September 4, 2014

**Subject: Convenience Store and Fuel Station Development – 2282 Congress Street**  
**Applicant: Portland Property Holdings, LLC**  
**Response to Ben Viola’s Review Comments Dated August 22, 2014**

Drawing file: Aug8_misnum sub / C-9.1A.pdf

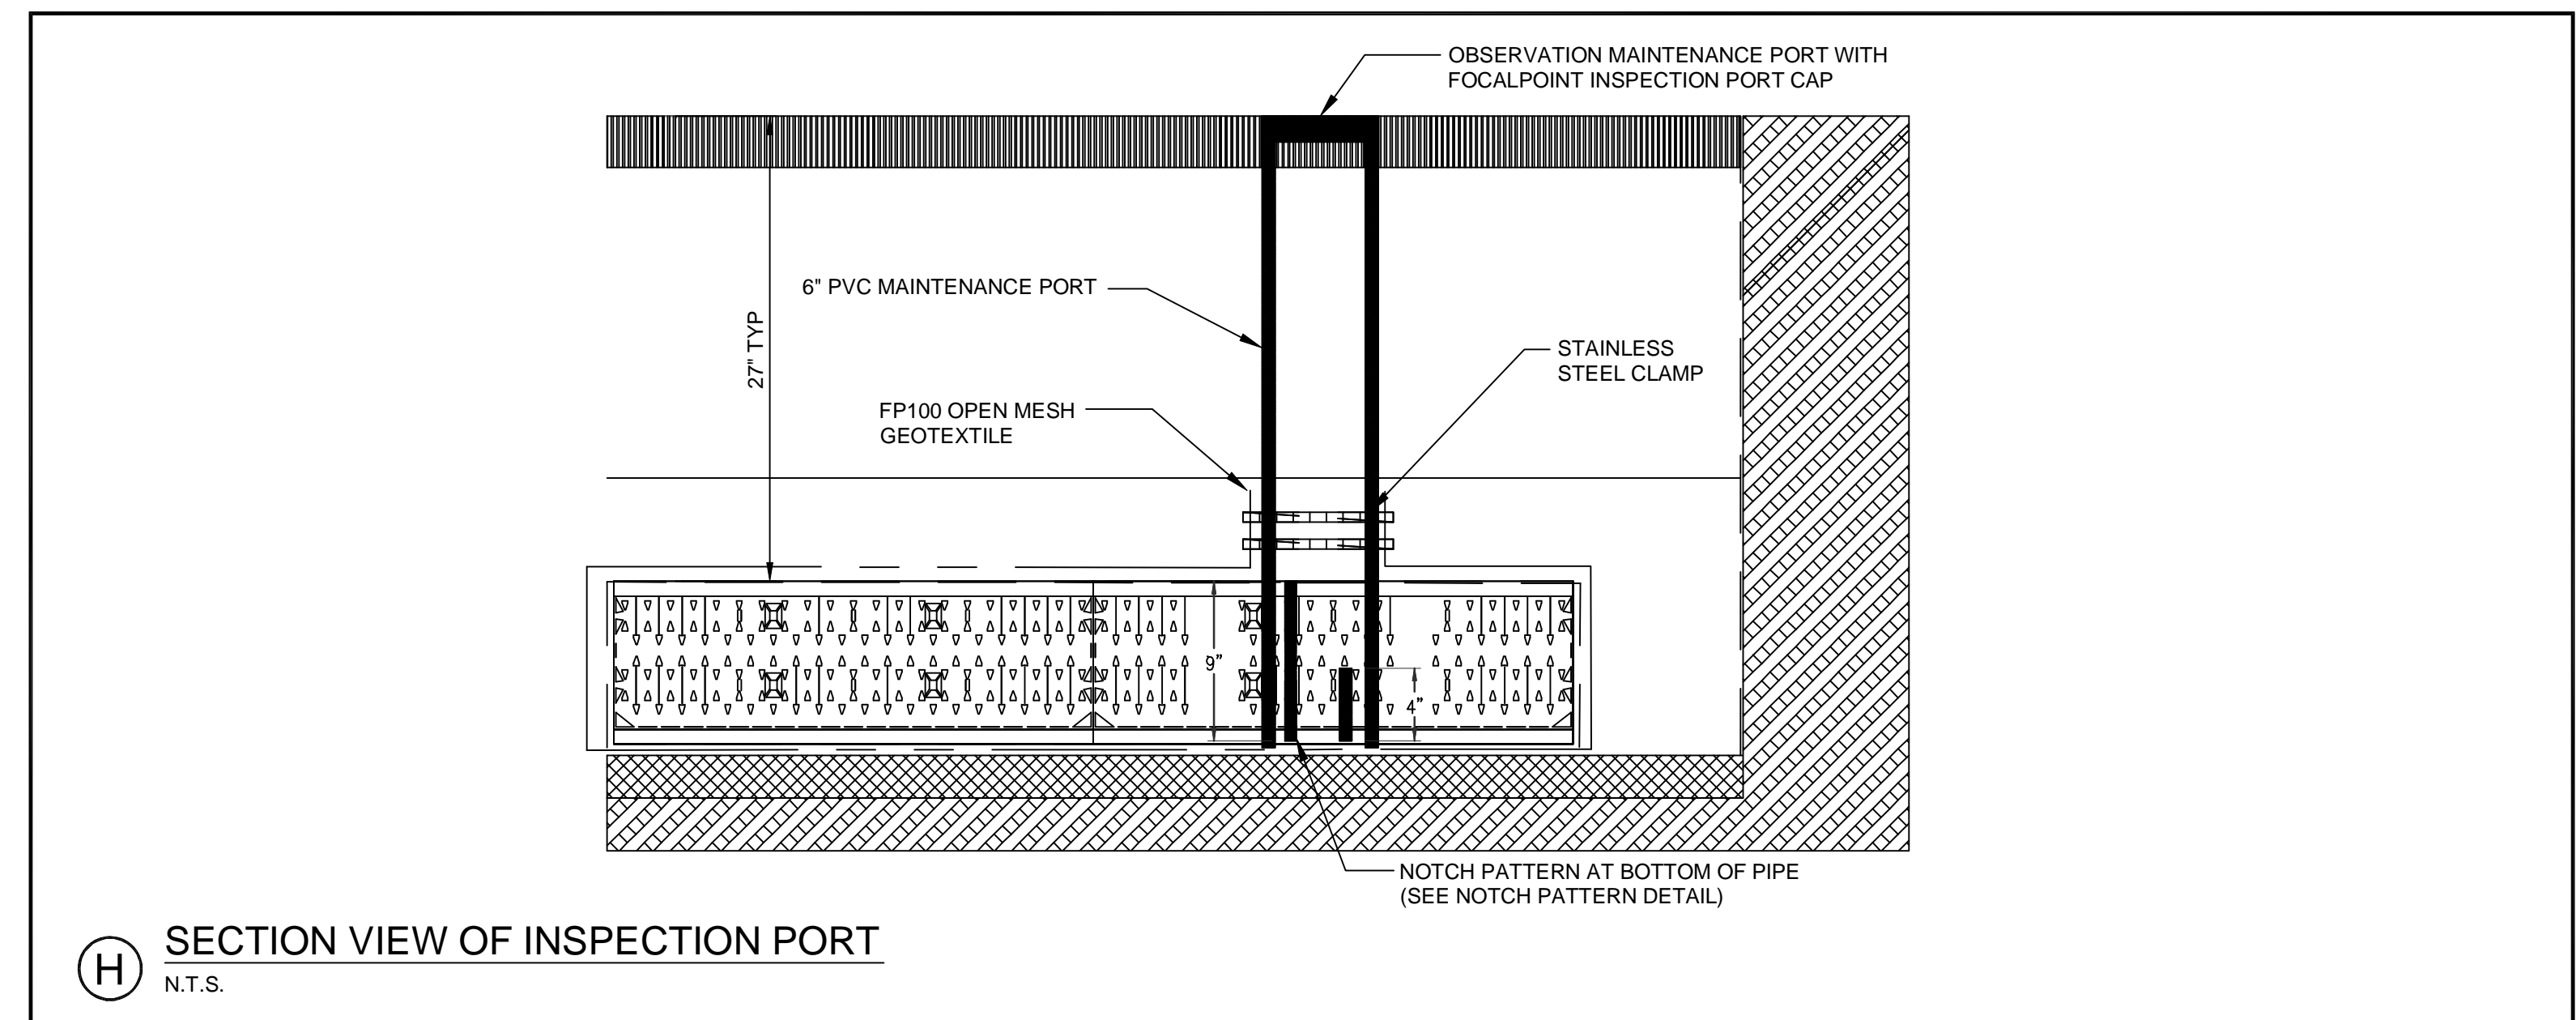
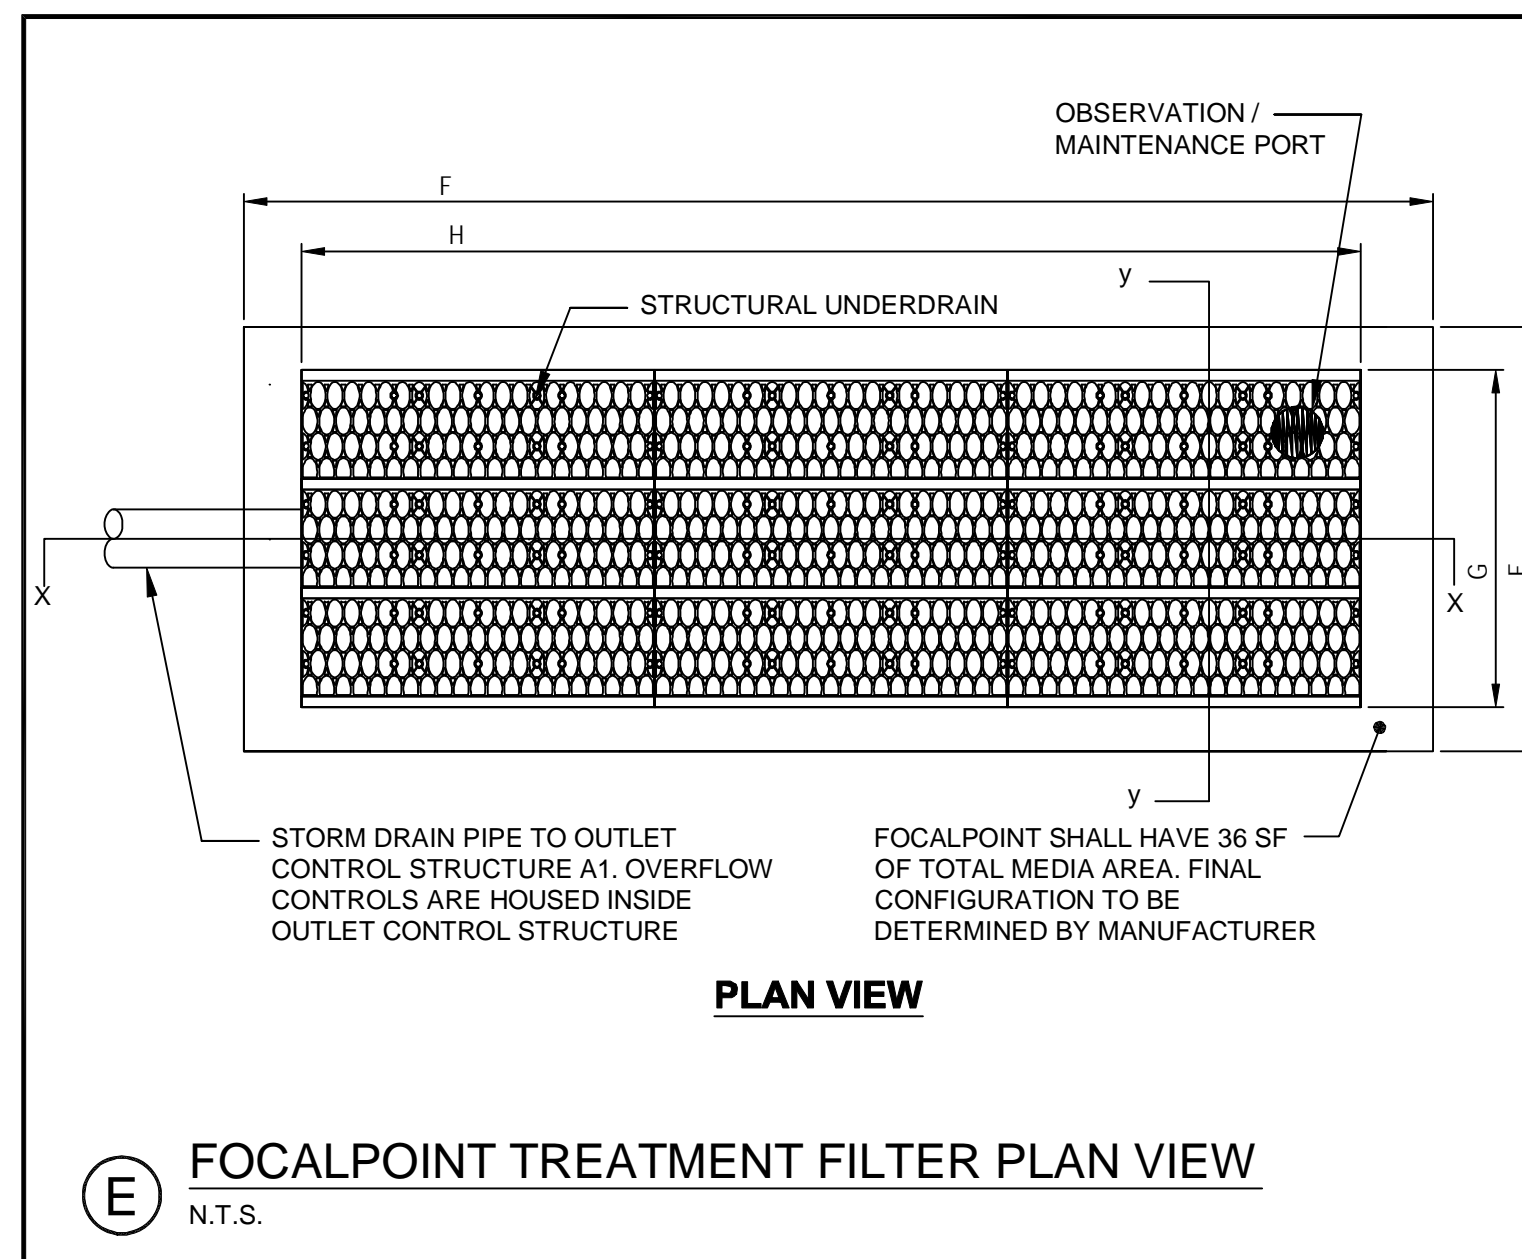
*Currently we are not approving the Focal Point in this type of application. Therefore this option must be removed from the plan set.*

Design Sheets C-9.0A and C-9.1A have been eliminated from the plan set. The project stormwater will be treated using a grassed underdrained soil filter as shown on Sheets C-9.0 and C-9.1
